From: Zac Denton
Sent: 29 August 2019 13:06
To: Planning.Responses
Cc: Lynnyrd Wolfe
Subject: FW: LU/184/19/HH - 14 Esher Drive, Littlehampton.
Attachments: 2962-02 revB Existing Proposed Plans Elevations.pdf; 2962-03 revB Location Block Plan.pdf

Subject: RE: LU/184/19/HH - 14 Esher Drive, Littlehampton.

Client:	Ms Donovan
Project:	Extensions and Alterations to: 14 Esher Drive Littlehampton West Sussex BN17 6AA
Drawing title:	Floor Plans & Elevations Existing & Proposed
Scale:	1:100 @ A1
Date:	15.05.19
Drawn:	KWF
Drawing number:	2962-02
Revision:	B

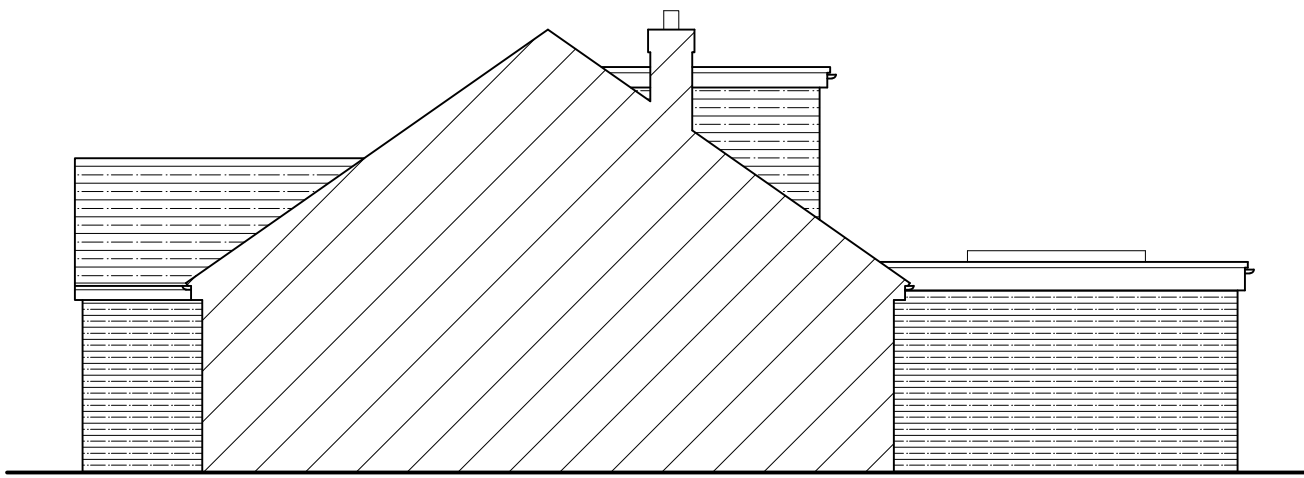
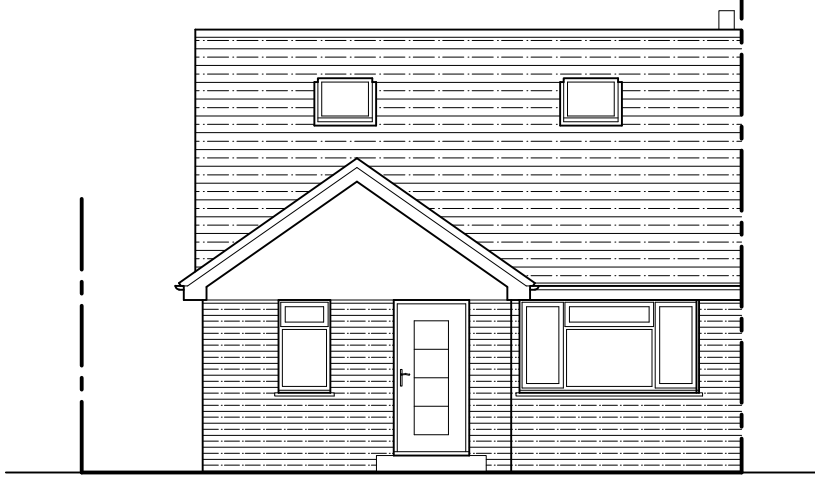
The concerns largely related to the front dormer, as it is not considered to be an acceptable addition to the host dwelling.

If this were to be removed from the application, it would be looked upon more favourably.

Apologies for the delay in responding. Please find attached revised plans with the proposed front dormer removed.
